## Fire Marshal Division

**RE: Papa Subs & Pizza**  
**117 W. Cornelius Harnett Blvd.**  
**Lillington, NC 27546**

**Application Number – FMFW2103-0003**

F-1

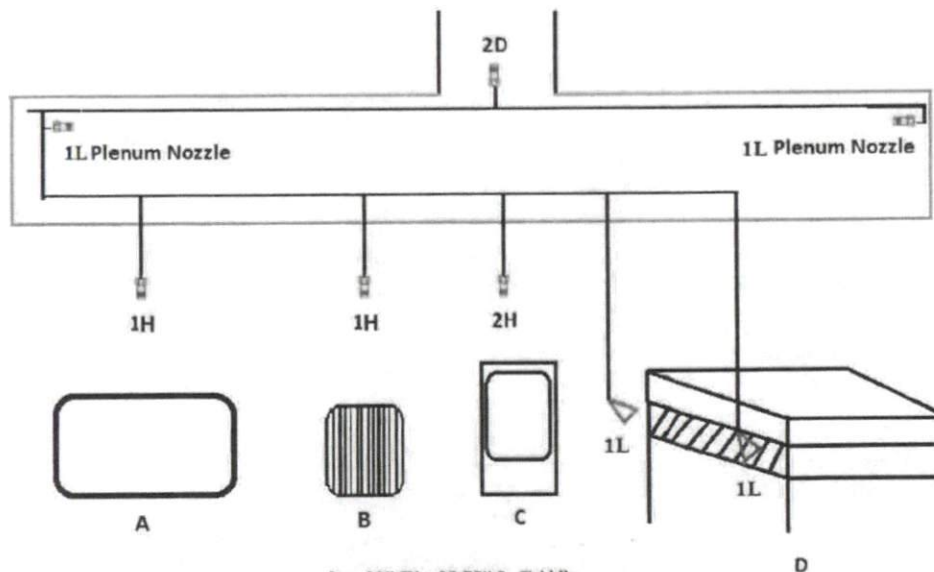
- **Manual system operation of Commercial Hood System**
  - A manual actuation device shall be located at or near a means of egress from the cooking area, a minimum of 10 feet (3048 mm) and a maximum of 20 feet (6096 mm) from the kitchen exhaust system. The manual actuation device shall be located a minimum of 4.5 feet (1372 mm) and a maximum of 5 feet (1524 mm) above the floor. The manual actuation shall require a maximum force of 40 pounds (178 N) and a maximum movement of 14 inches (356 mm) to actuate the fire suppression system.

- **System Interconnection of Commercial Hood System**
  - The actuation of the fire suppression system shall automatically shut down the fuel or electrical power supply to the cooking equipment. The fuel and electrical supply reset shall be manual.
